Application for Planning Permission for Works or Extension to a Dwelling

Development: Proposed Garage.
Location: 16 Sea Way Middleton-On-Sea PO22 7SA

Proposed East Elevation

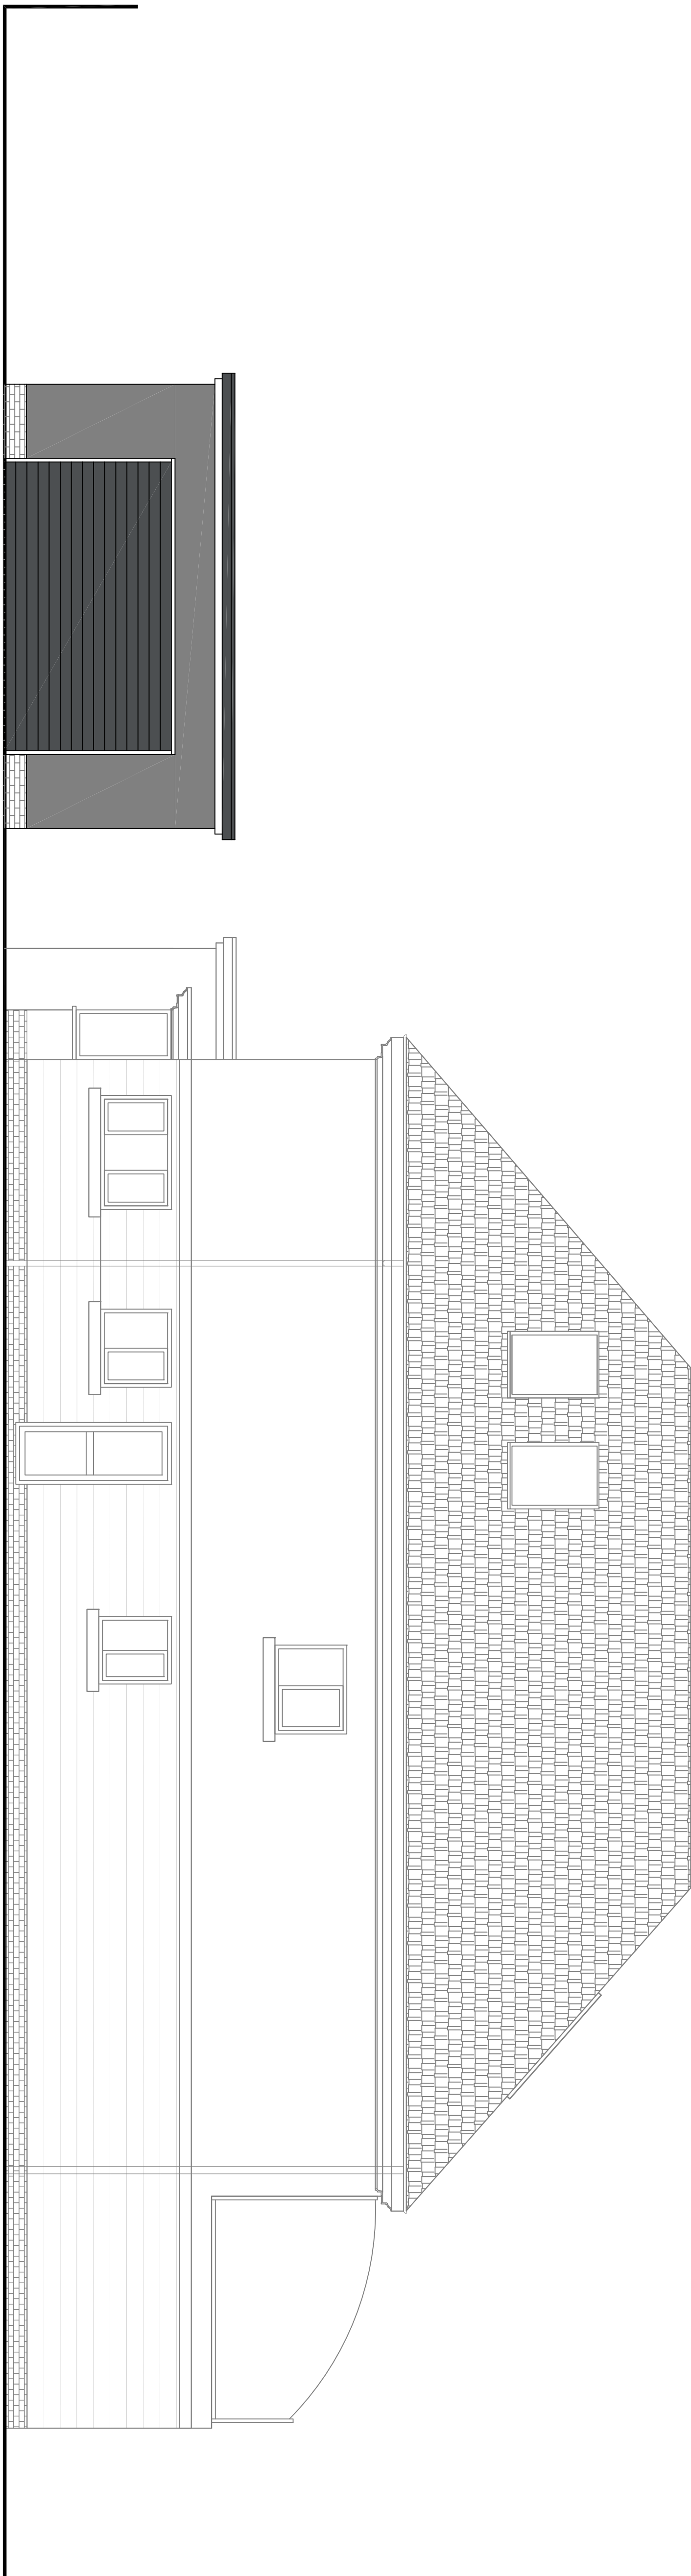
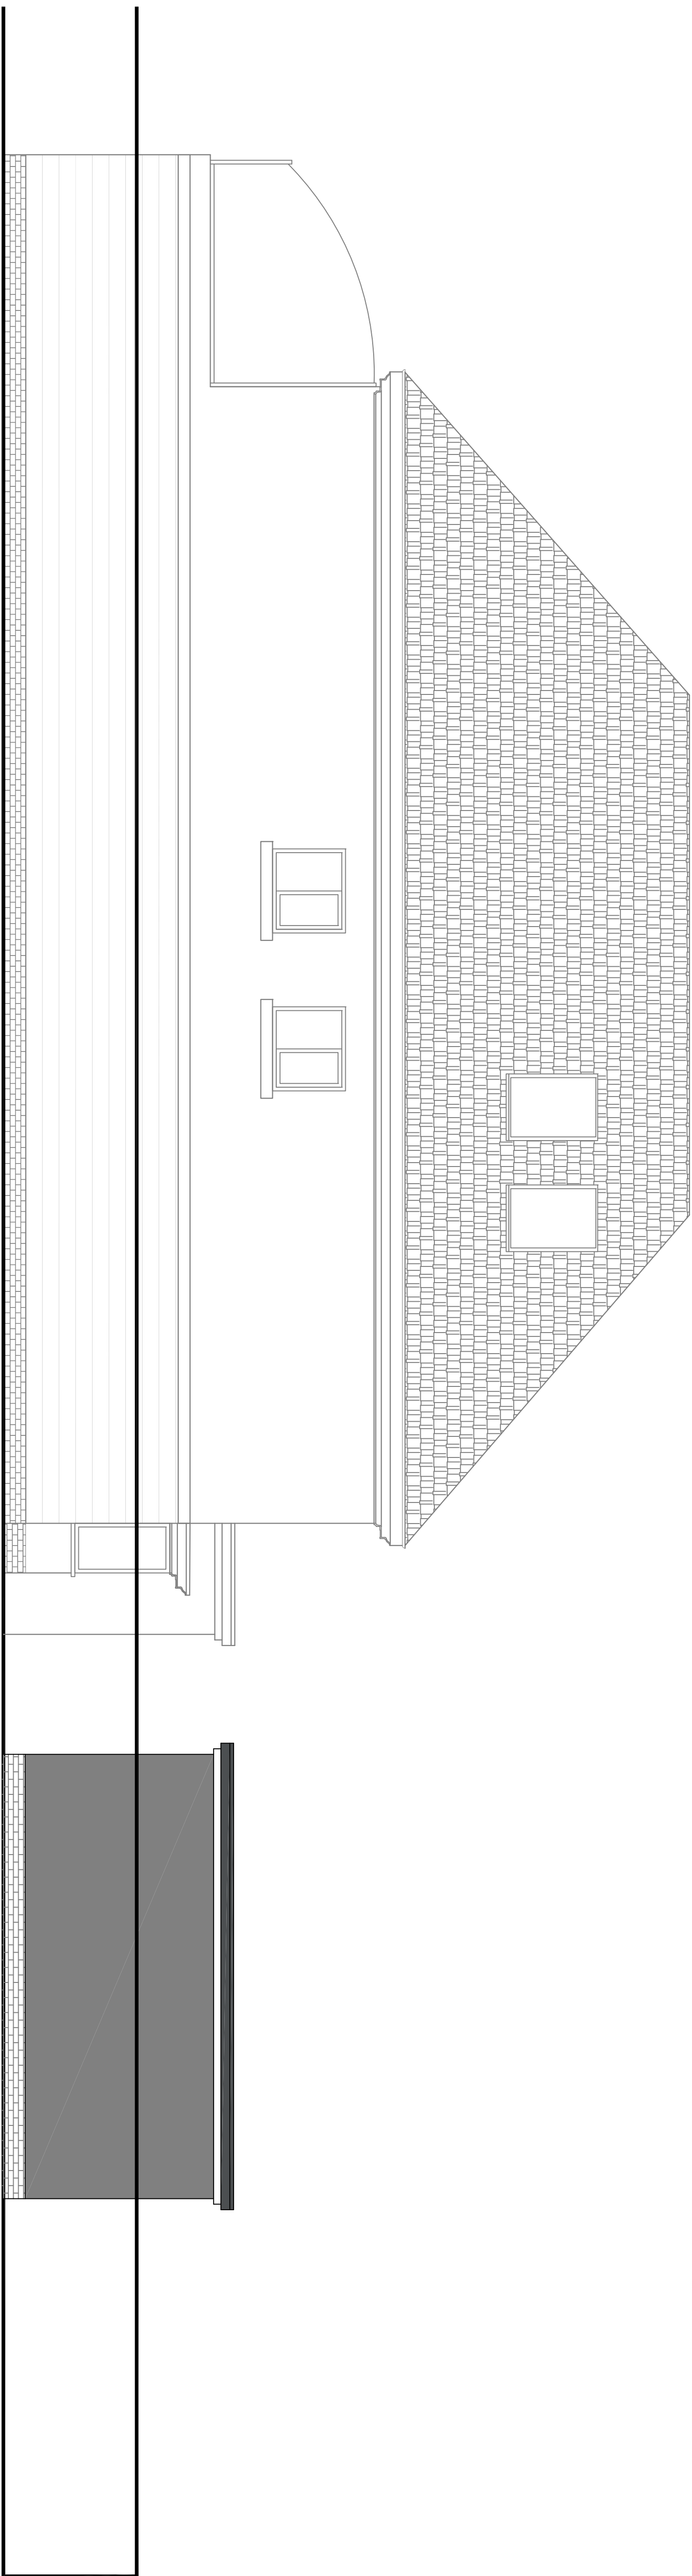
The proposed east and west elevation plan requires a scalebar.

Proposed North Elevation

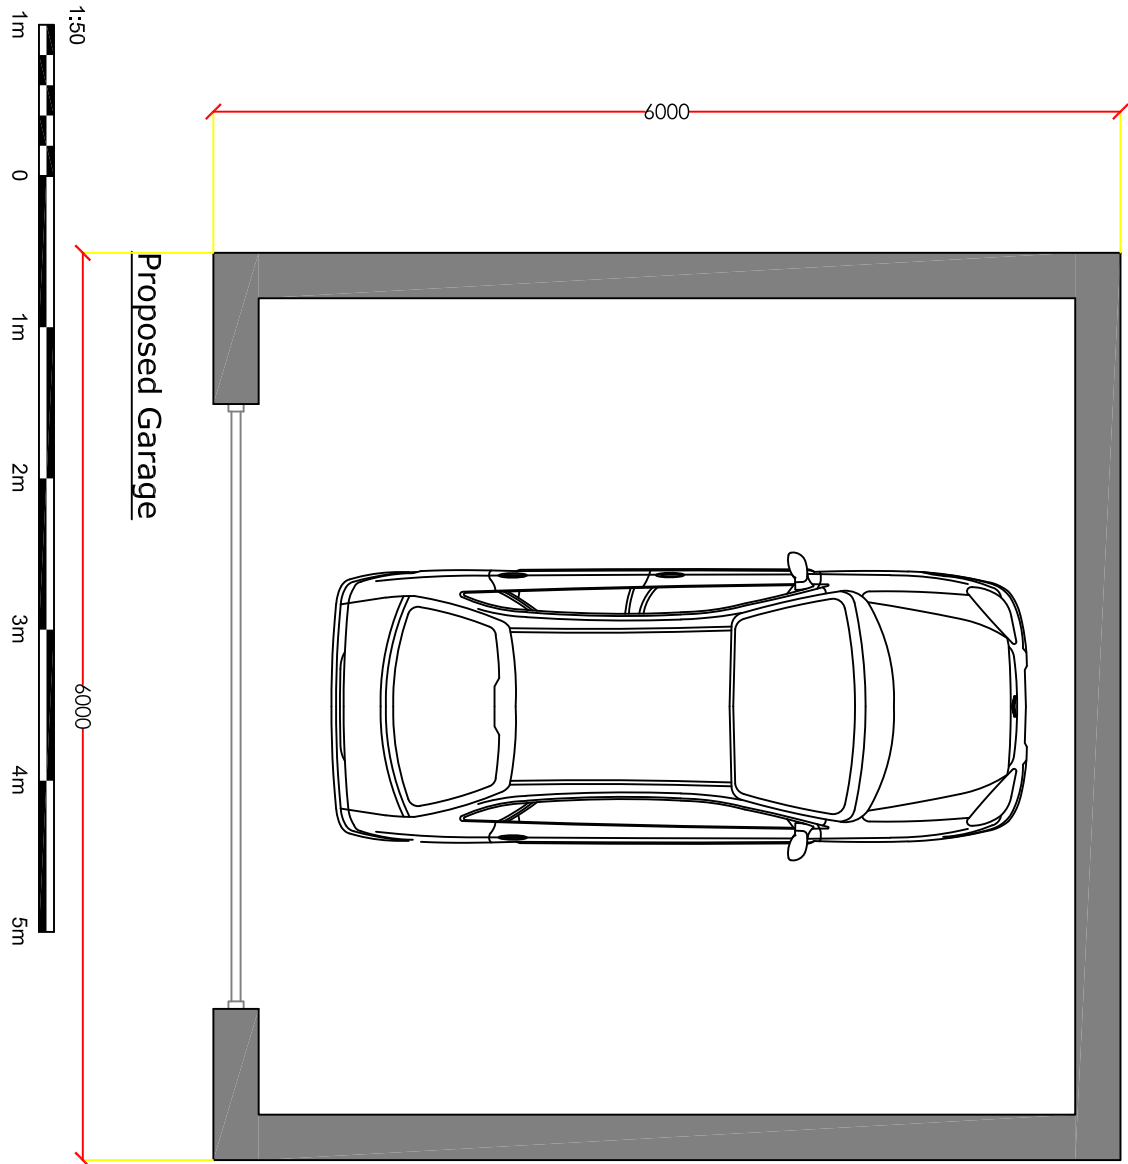
The proposed north elevation plan.

The dwelling roof lights are inconsistent with other plans representing the dwelling.

Proposed Car Port Planning
Date January 2026
Scale 1:200 1:1250

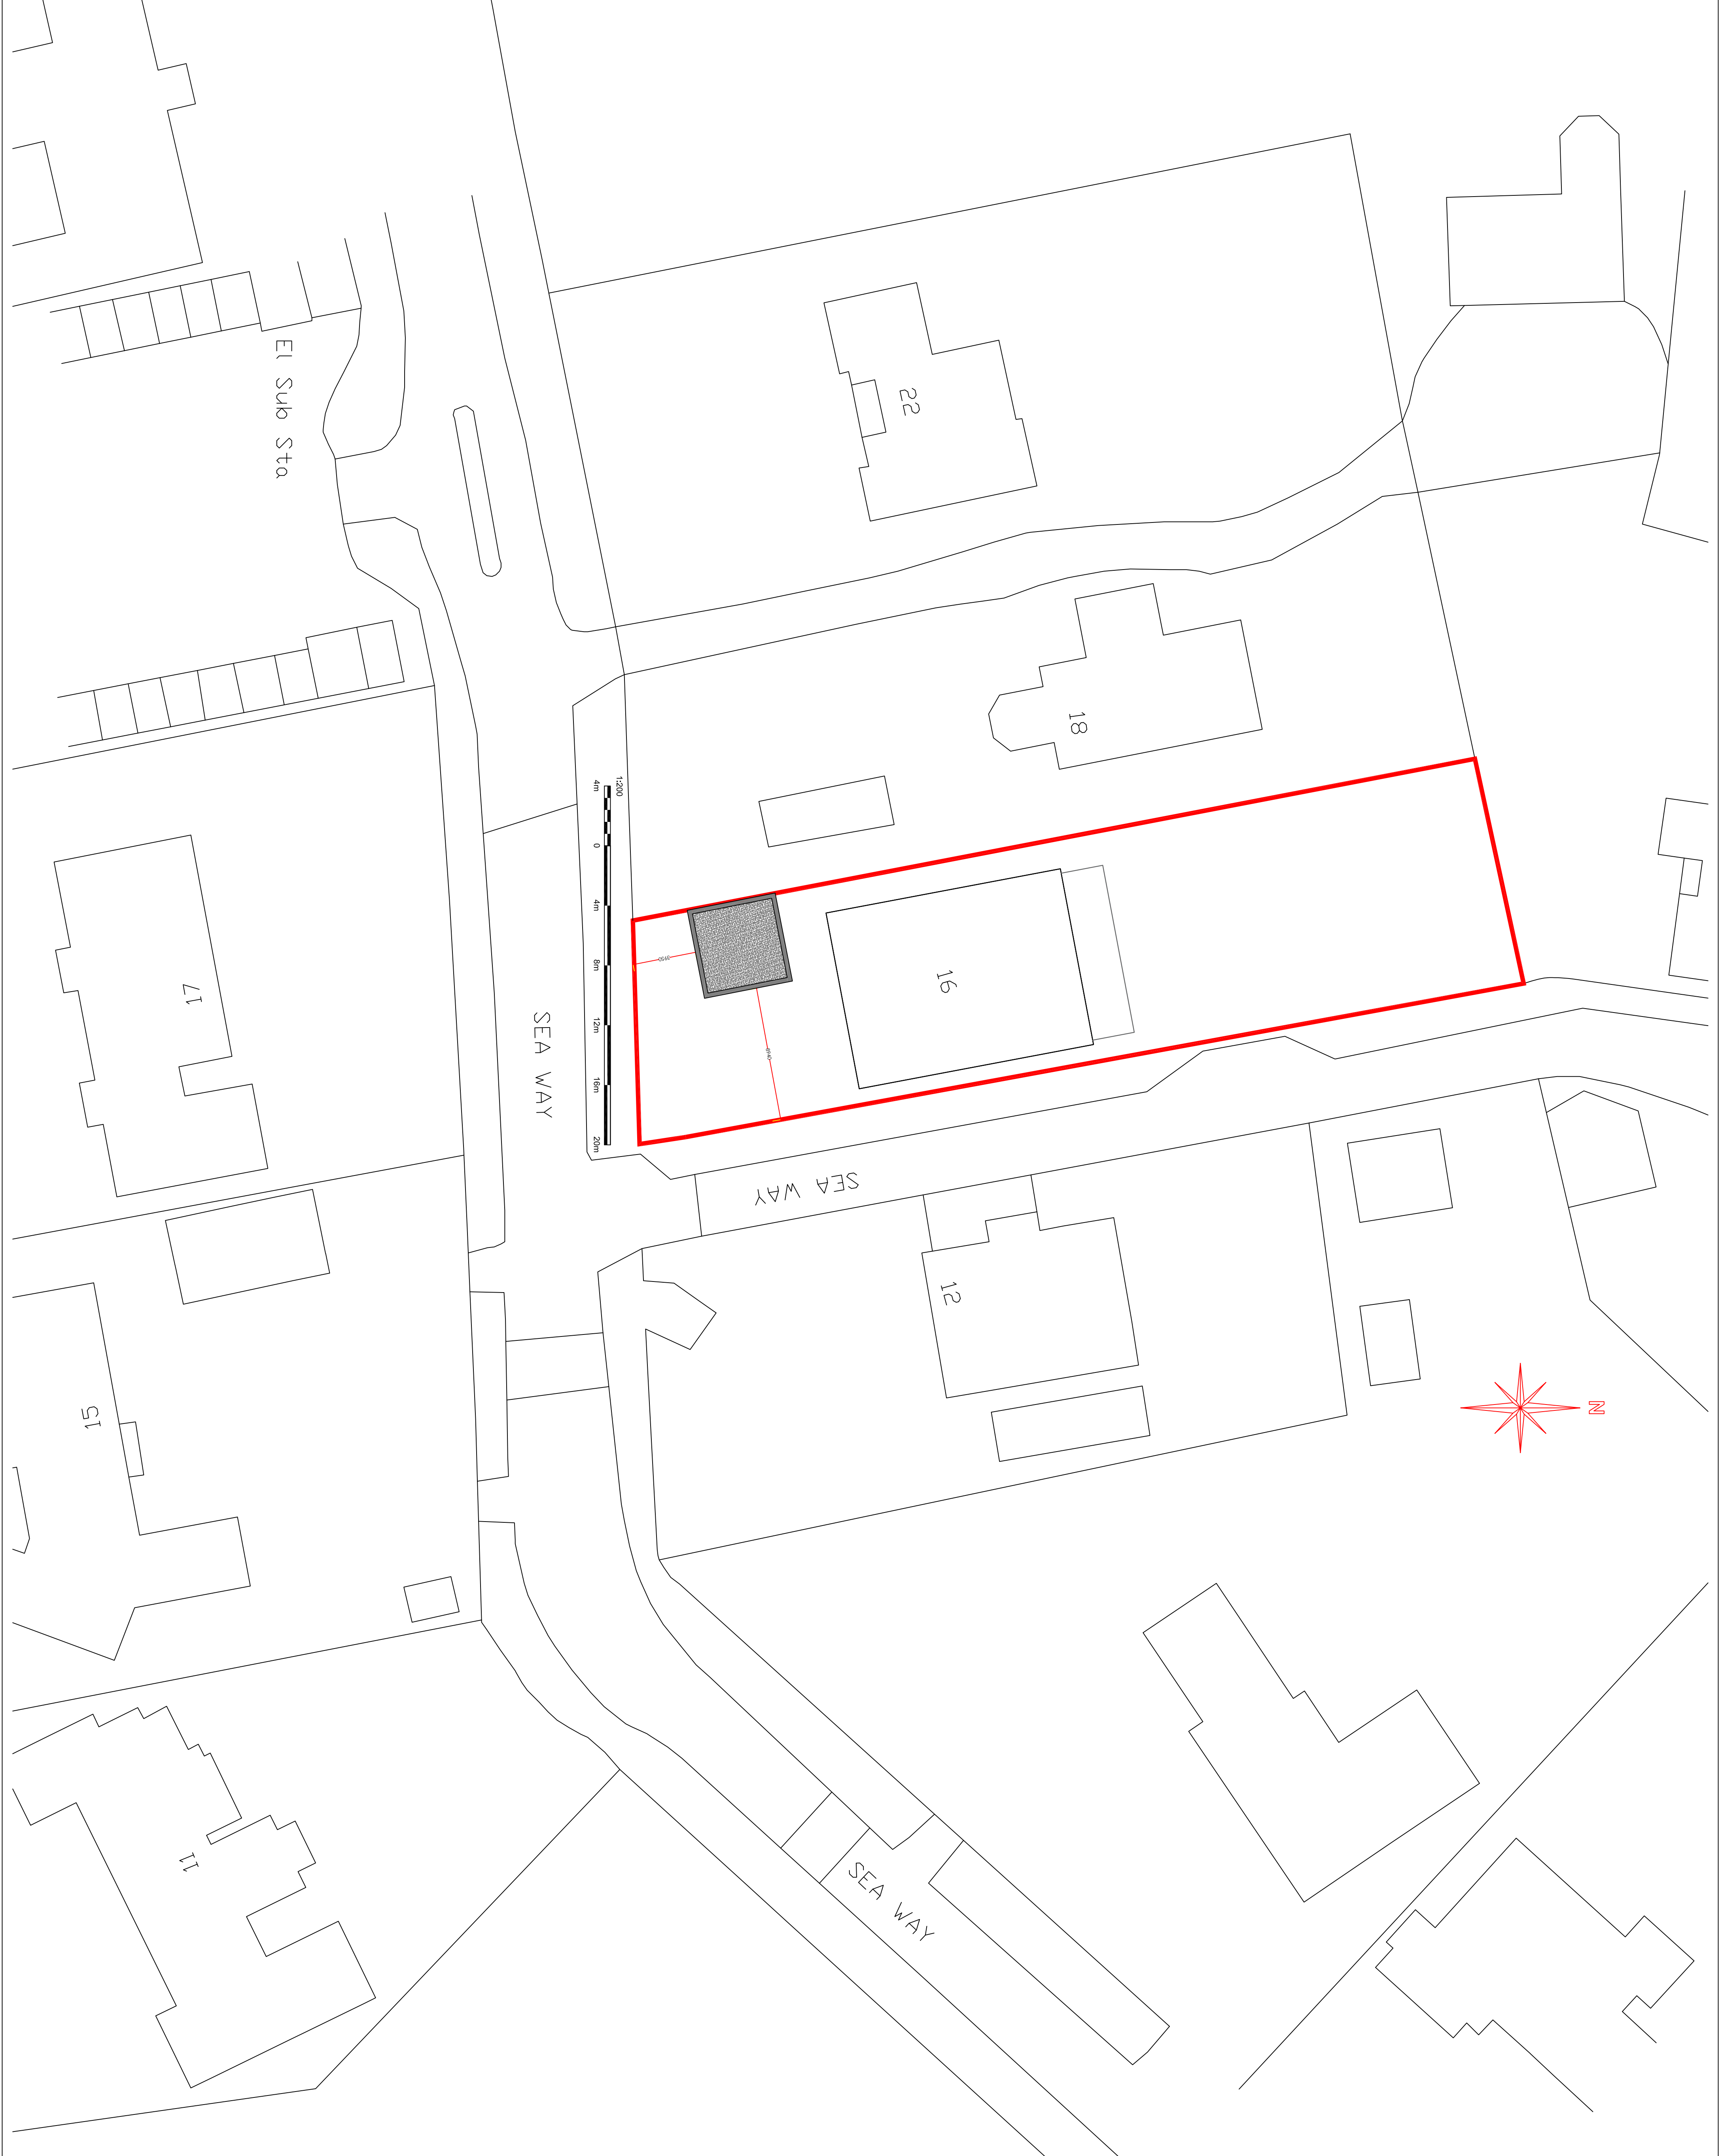
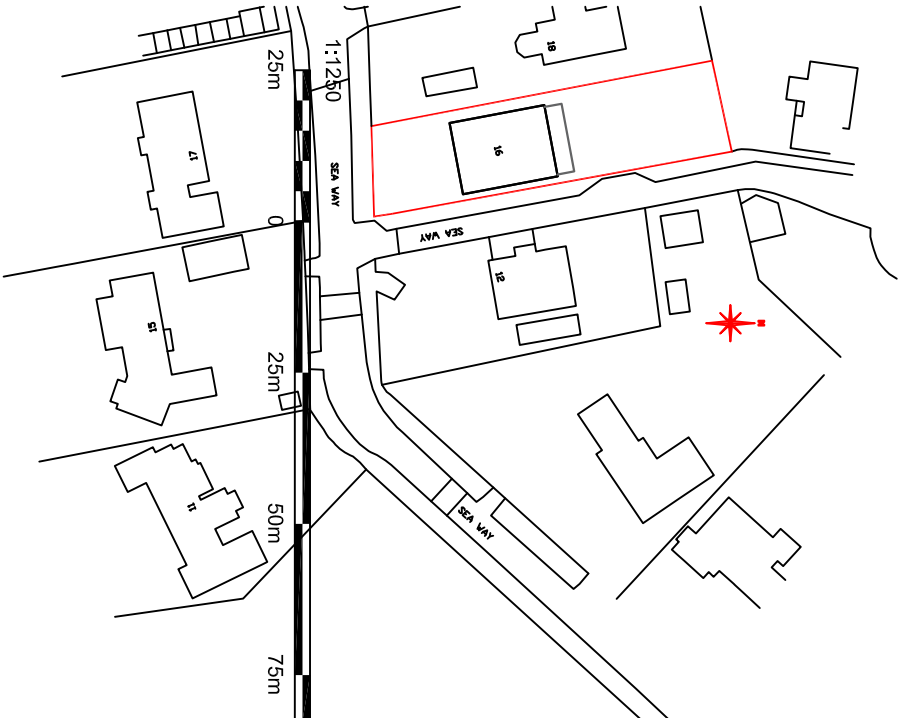
The location plan provided requires a scalebar and should be existing.

Each plan on a page with a different scale requires its own scale and scalebar.
